# PORTLAND MAINE

June 9, 2011

**Project Name:** Outdoor Patio, Bowl Portland      **Project ID:** 2011-204  
**Address:** 58 Alder Street

FD.1
Level 1 Site
Plan Alteration

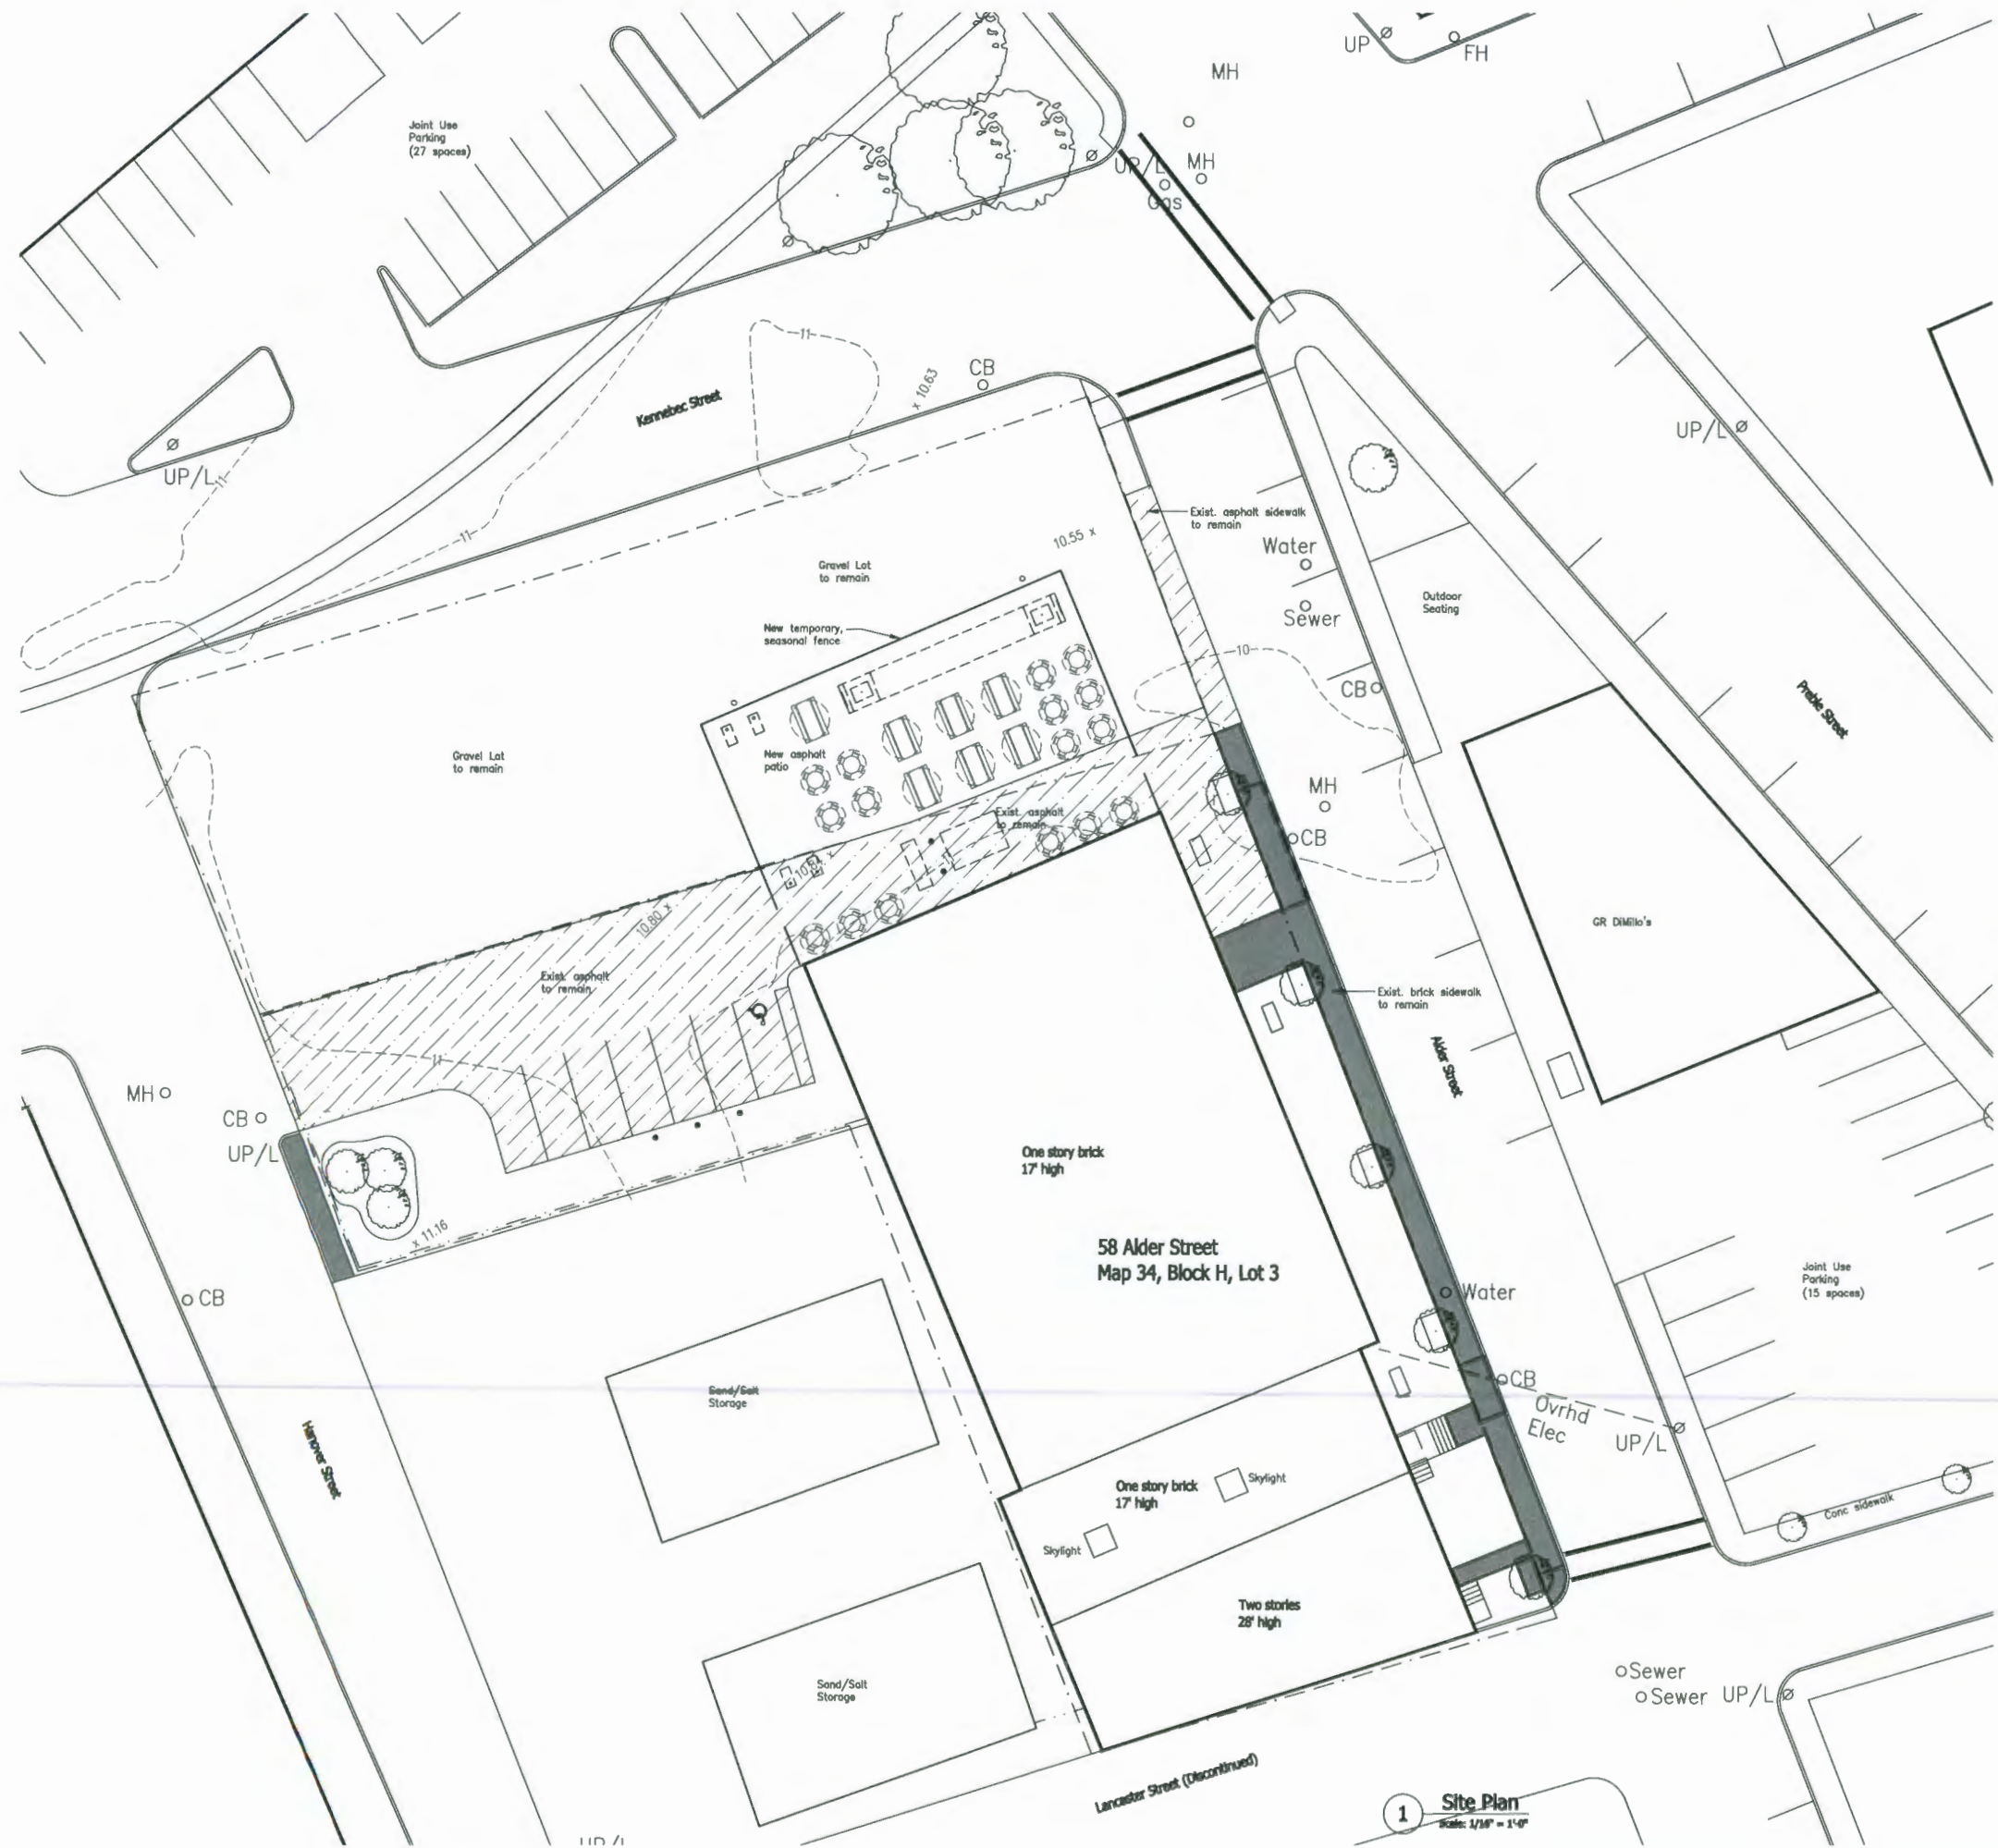
We have reviewed the plans prepared by David Matero of DayMatero Studio. You propose to pave approximately 2,757 sq ft on the site for use as an outdoor seating space and outdoor game area (such as horseshoes and cornhole toss). The total patio area will measure 4,140 sq ft. You also propose to place a metal interlocking fence around the perimeter which will be removed when the patio closes for the season.

**2. Fencing and Landscaping.** Given the seasonal nature of the project, the proposed removable fencing is permitted, just as one would use temporary barriers at a sidewalk café to provide separation between pedestrians and the patrons. If the applicant decides in the future to install permanent fencing, the City's technical specifications will apply.

Landscaping, including trees, will be required to be planted as part of the permanent site work. In the meantime, at a minimum, planters with flowers and/or plants are expected to be included as part of the project.

**3. Property survey and property pins.** A property survey is on file; property pins need to be set at all property corners.
